November 6, 2019

RE: Presbyterian Hospital Expansion 1100 Central SE et al. Conceptual Grading and Drainage Plan Engineer's Stamp Date: 10/29/19 Hydrology File: K15D005

Based on the submittal received on 10/29/19, the Grading and Drainage Plan is approved for Site Plan for Building Permit.

C-101

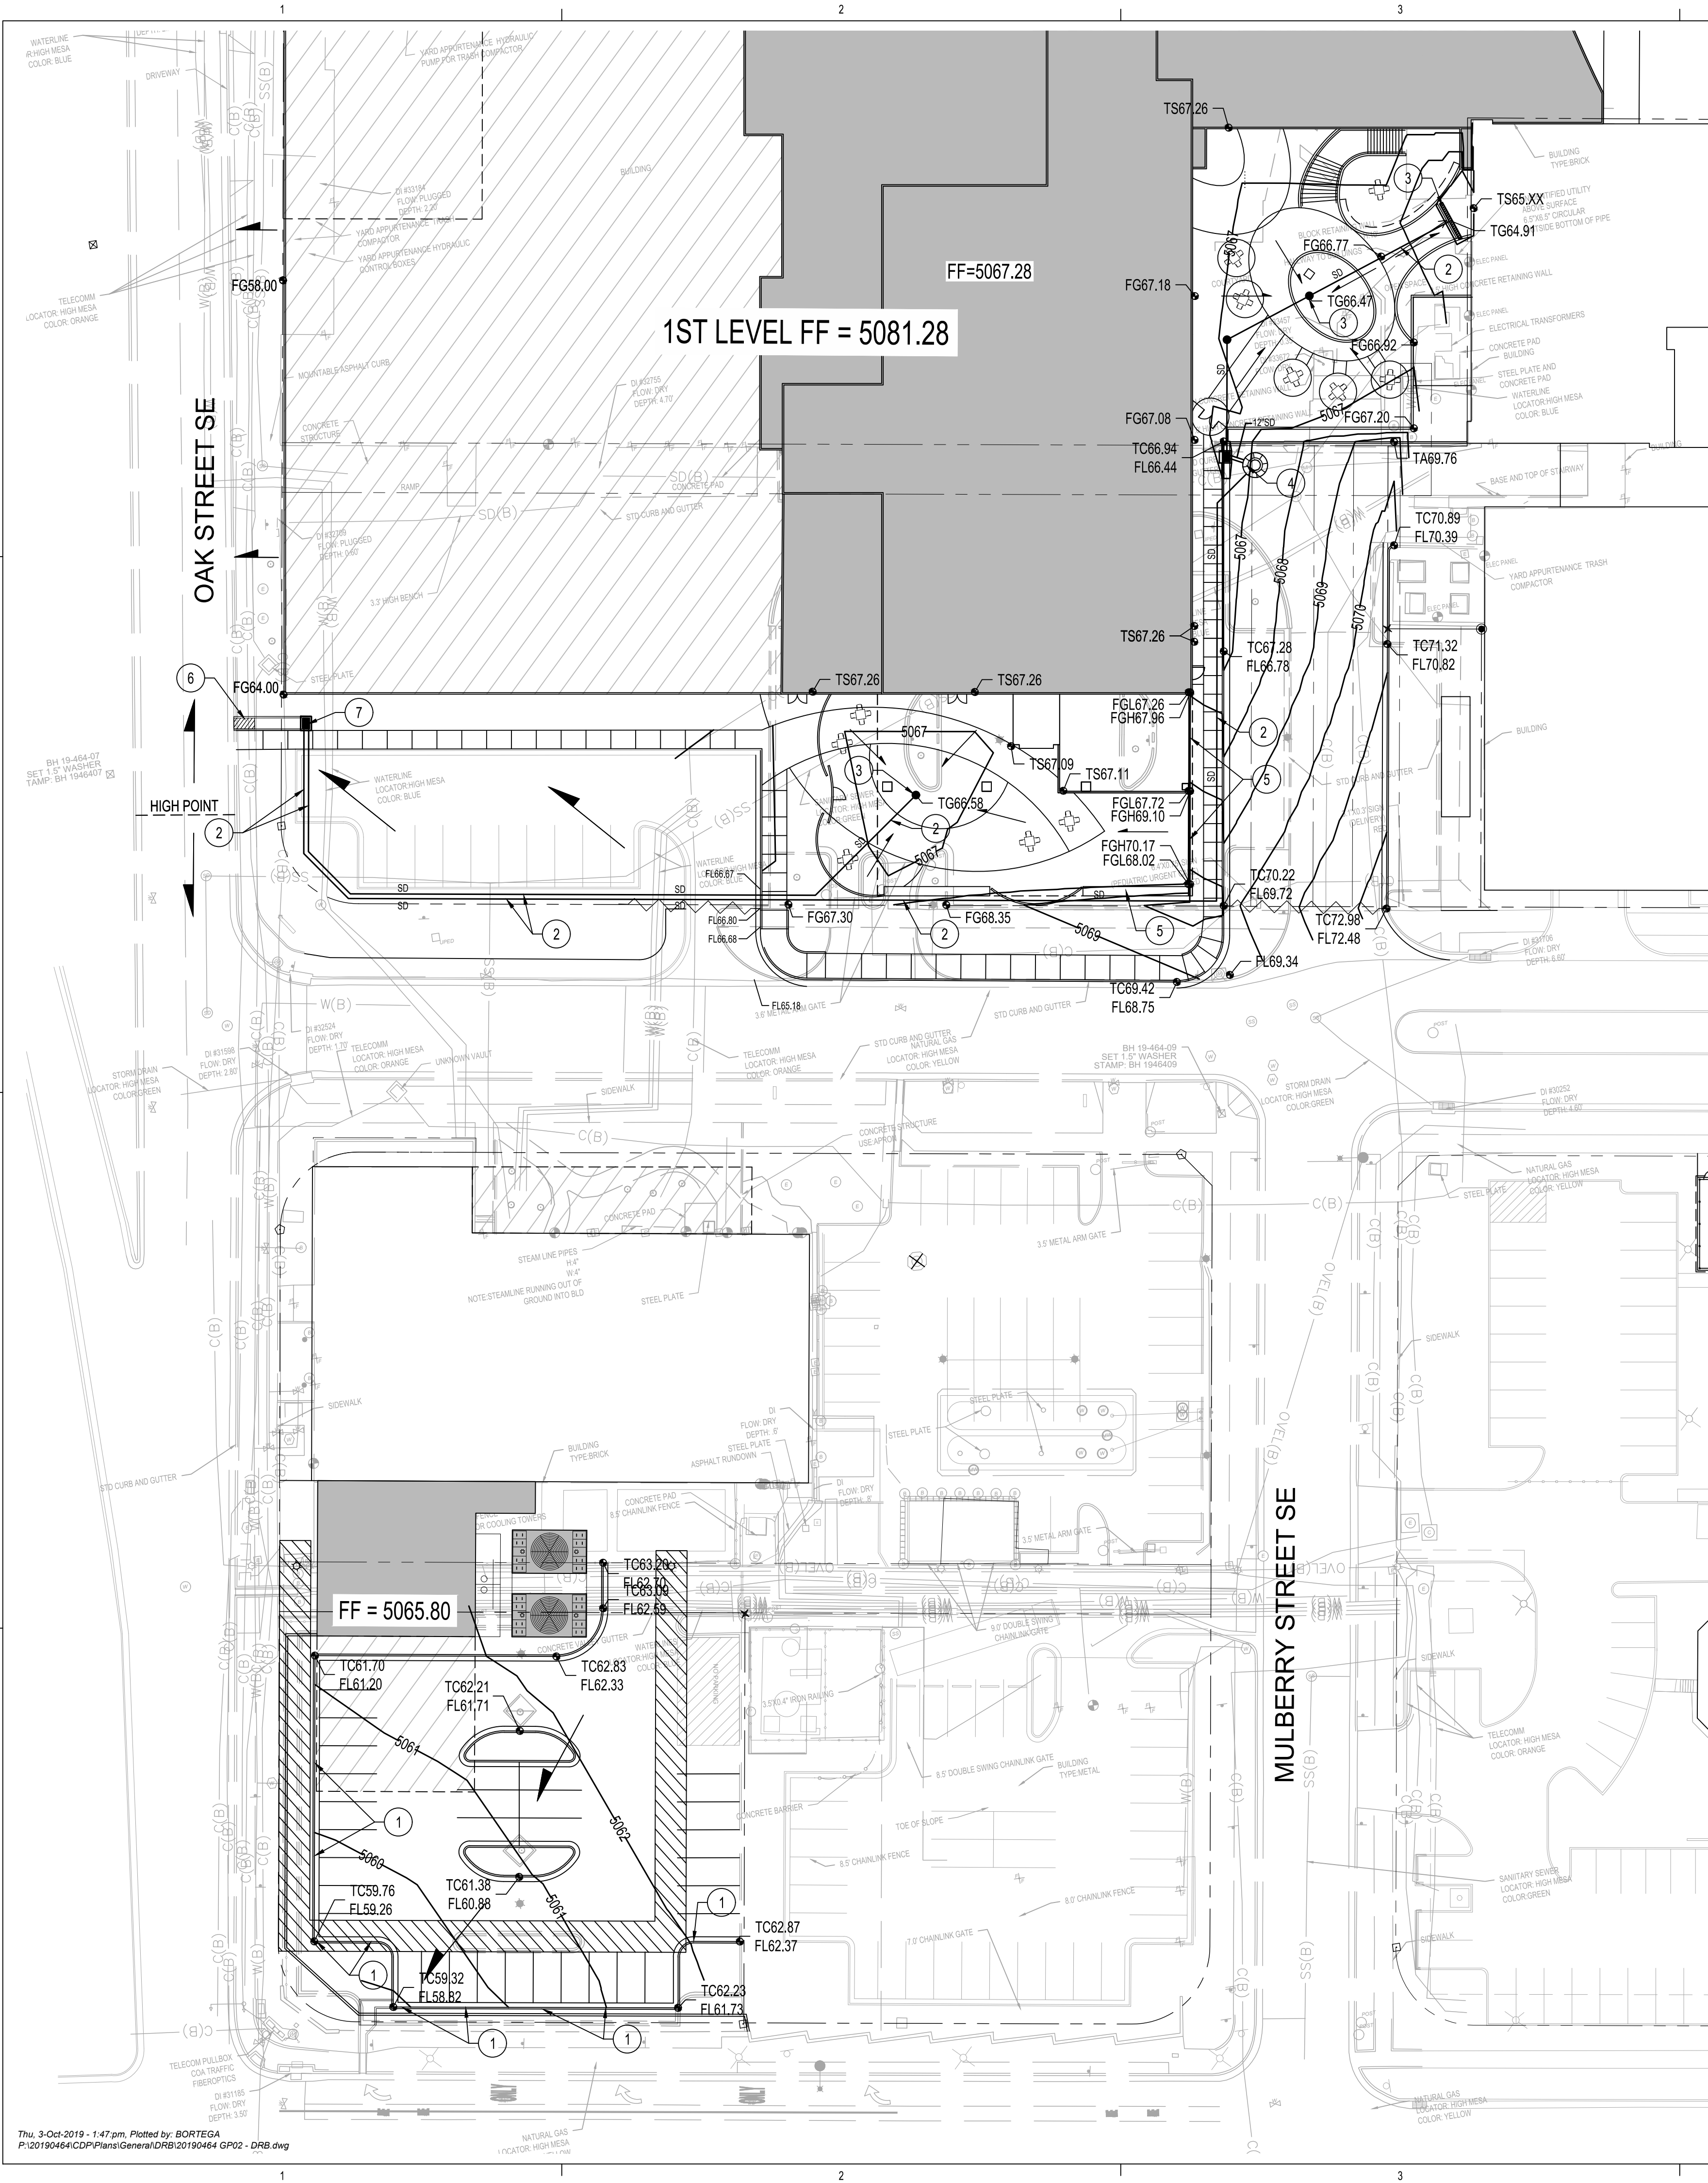
2. Identify the addresses (and Building Permit #, if known) of each viewport and label on the plan. This will smooth the process for obtaining Certificate of Occupancy.

- 3. Identify the area where fee-in lieu was already paid during the "make ready" phase and ensure no overlap occurs in calculating the redeveloped impervious area for this project.

CONCEPTUAL
GRADING AND
DRAINAGE PLAN
AREA A

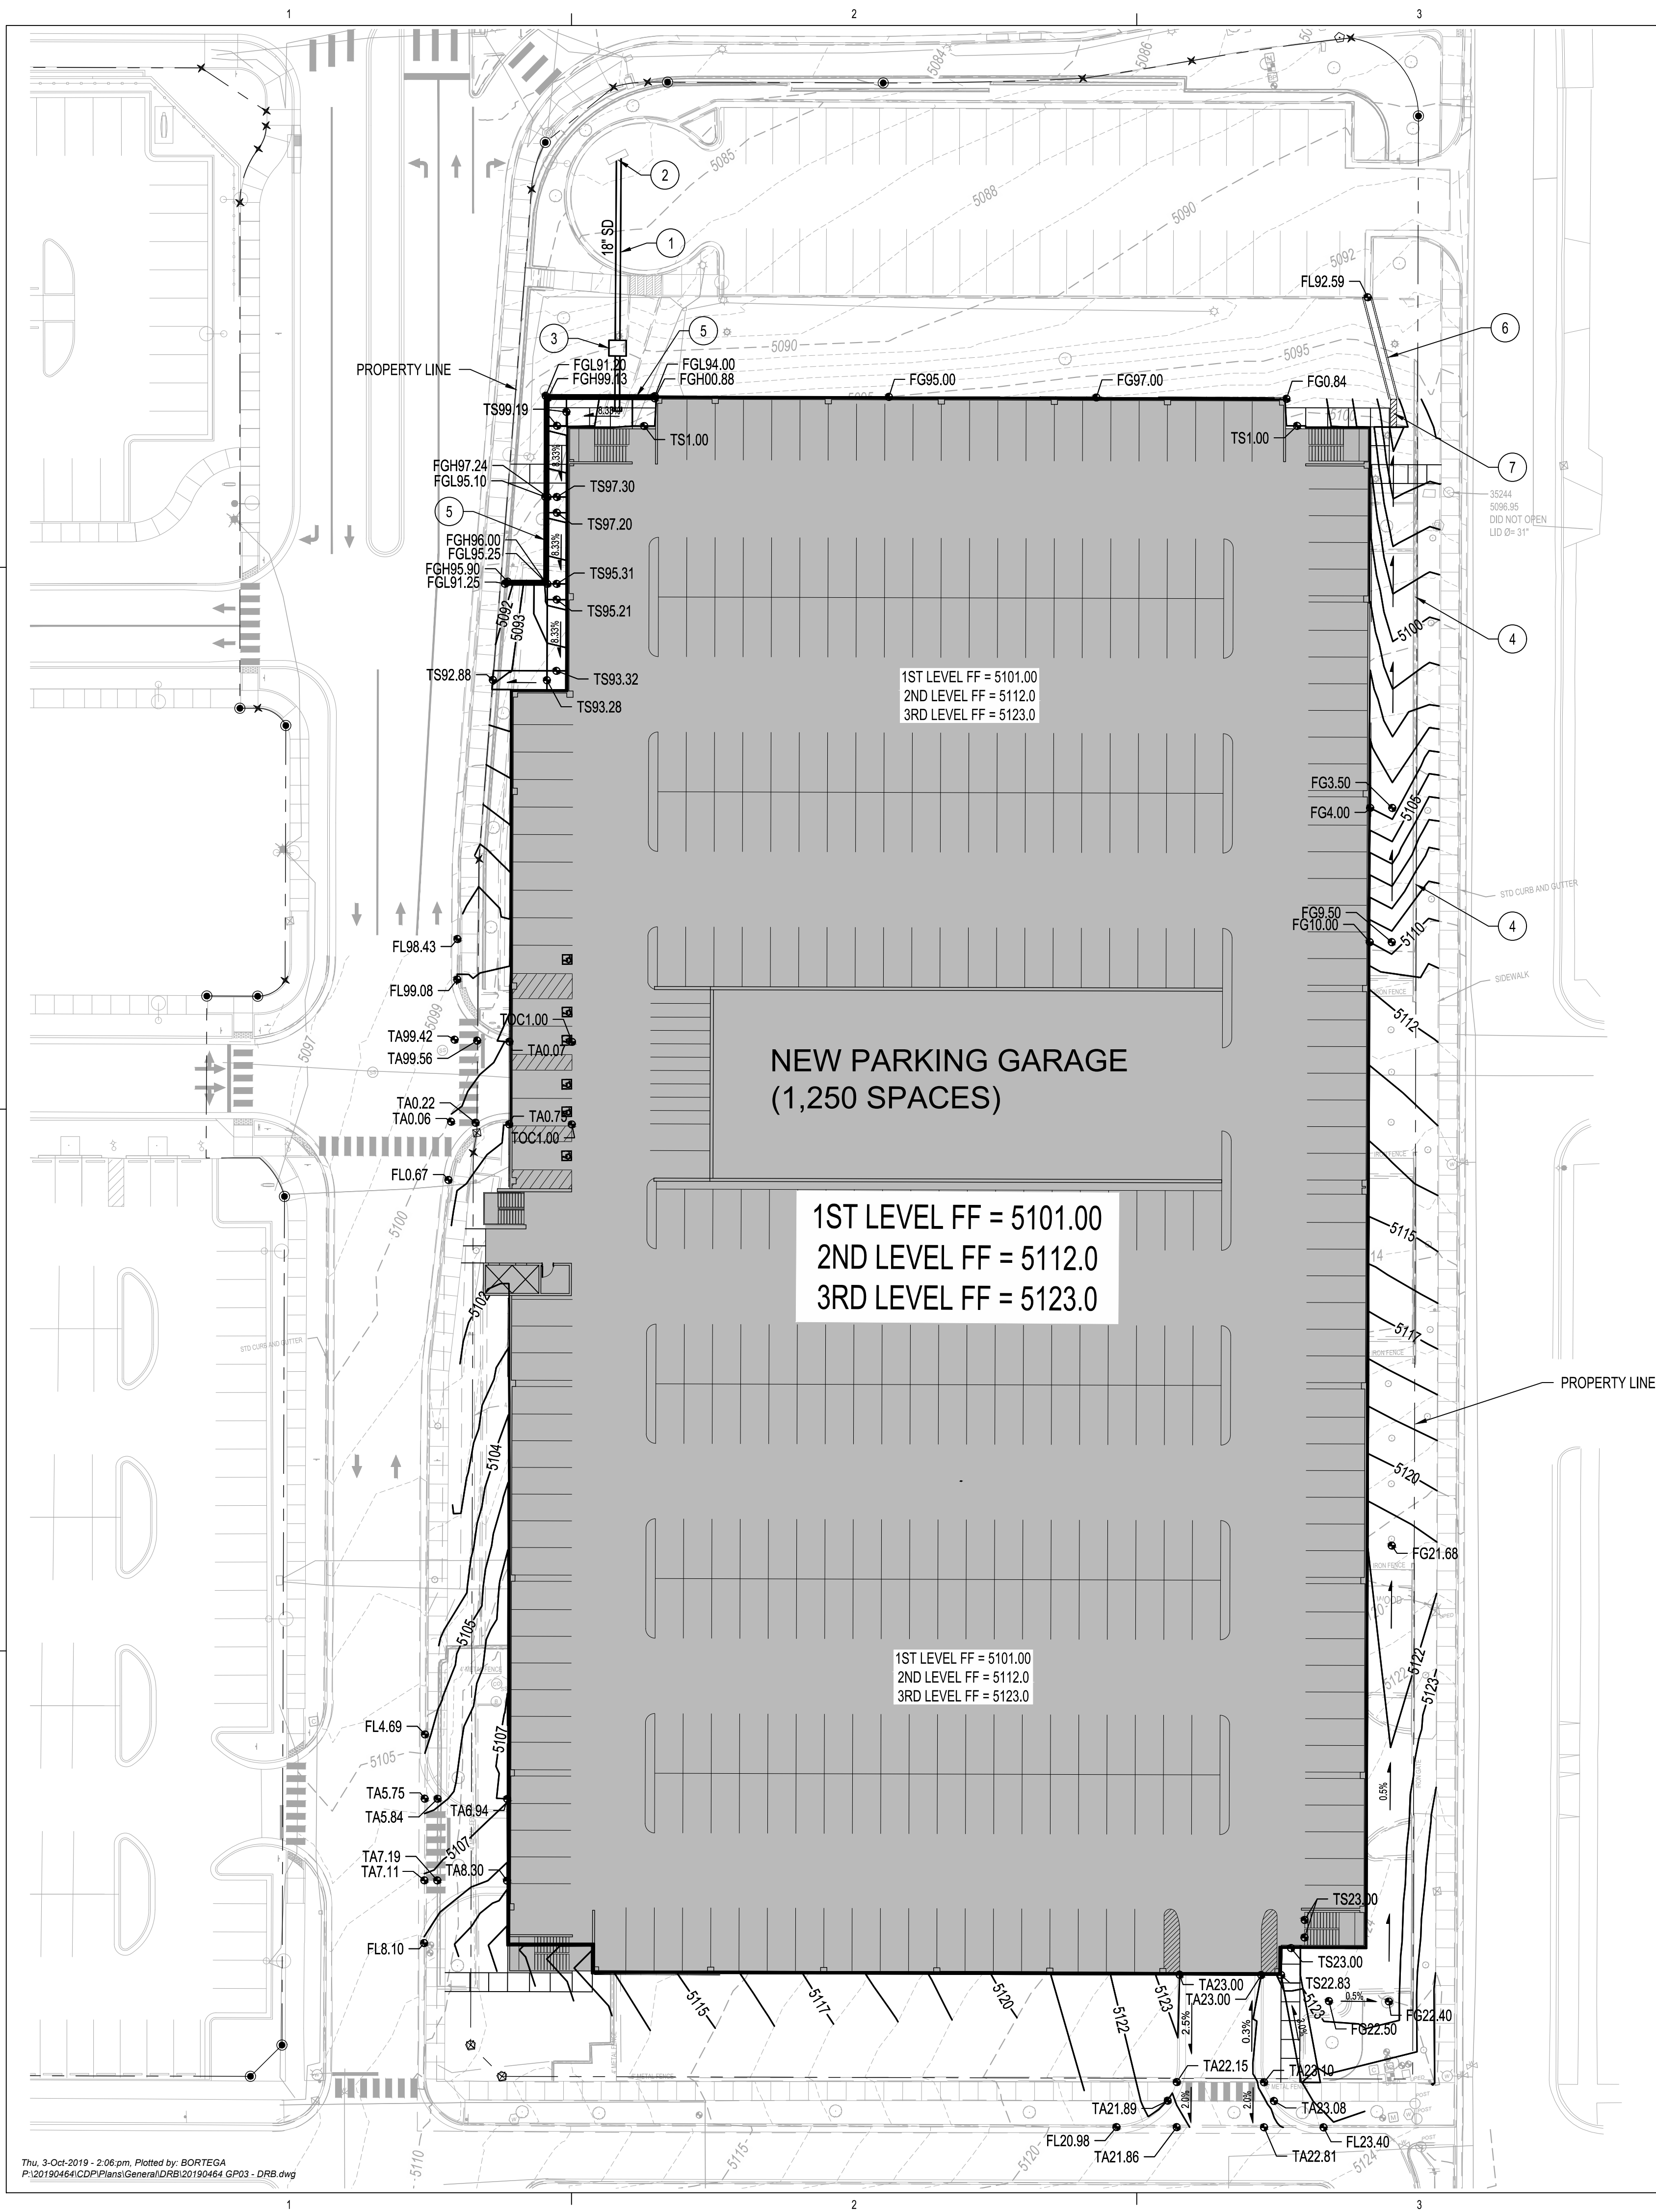
- 4. Payment in Lieu (Amount = TBD) of onsite management of the stormwater quality volume (SWQV) must be made. Provide SWQV calculations.
- 5. Provide hydraulic calculations for the proposed storm drain system (Patient Tower area), calculated along the Energy Grade Line; include both the HGL and EGLs in the table.

- 6. Provide the design for the lift station. Include pump curves, a section showing elevations of pump-on, pump-off, max WSE, etc..., contributing area hydrology. Where is the emergency overland path, or the extents of the ponding if the pump fails?

- 7. Flow depth (and EGL) on Silver, in front of the garage entrance, needs to be calculated. Demonstrate that the EGL is less than the proposed waterblock height. Otherwise a standard 0.87' waterblock is required.
